**Consultation Response from KC,
Lead Local Flood Authority**

2023/92712 Land adjacent, 36 Oxford Road, Dewsbury, WF13 4LL

Erection of 40 bed care home and 12 independent supported living units (use class C2) with associated works including the formation of car park and service access

Date Responded: 03/11/2023.

FLOW CONTROL MANHOLE DETAIL

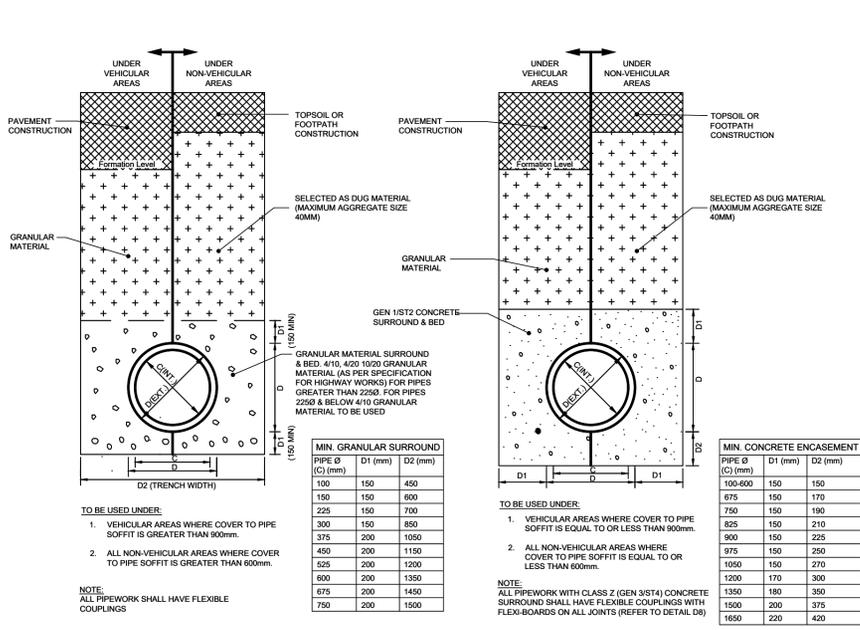
It is noted that the proposed hydrobrake has an outlet diameter less than 75mm and is therefore at an increased risk of blockage. Note that Building Regulations Part H states that no surface water pipes are to be less than 75mm diameter. Note further that Kirklees Council's acceptable present day greenfield run-off can be based on 5.0 l/s per ha – the greenfield rate should not be increased by the growth factors stated in Table in Section 7.1 of the SWM Plan. The LLFA accepts that the allowable discharge rate would need to be increased above the greenfield run-off rate such that the hydrobrake diameter is 75mm.

The LLFA does not understand why an orifice plate is provide – this would only discharge when the 1.2m deep tank is full and is a risk of blockage due to its small diameter. It would be preferable for the hydrobrake to be designed to discharge at the allowable rate against a design head equal to the tank full case for the 1 in 100 year (plus climate change) rainfall event. There is no need to have different discharge rates for the 2 year and 30 year rainfall events, the LLFA only require the critical 1 in 100 year event (plus climate change) to be contained within the site (but without flooding new or existing properties). Hydraulic calculations (updated as noted above) are expected to be submitted at the next design stage to indicate this is the case.
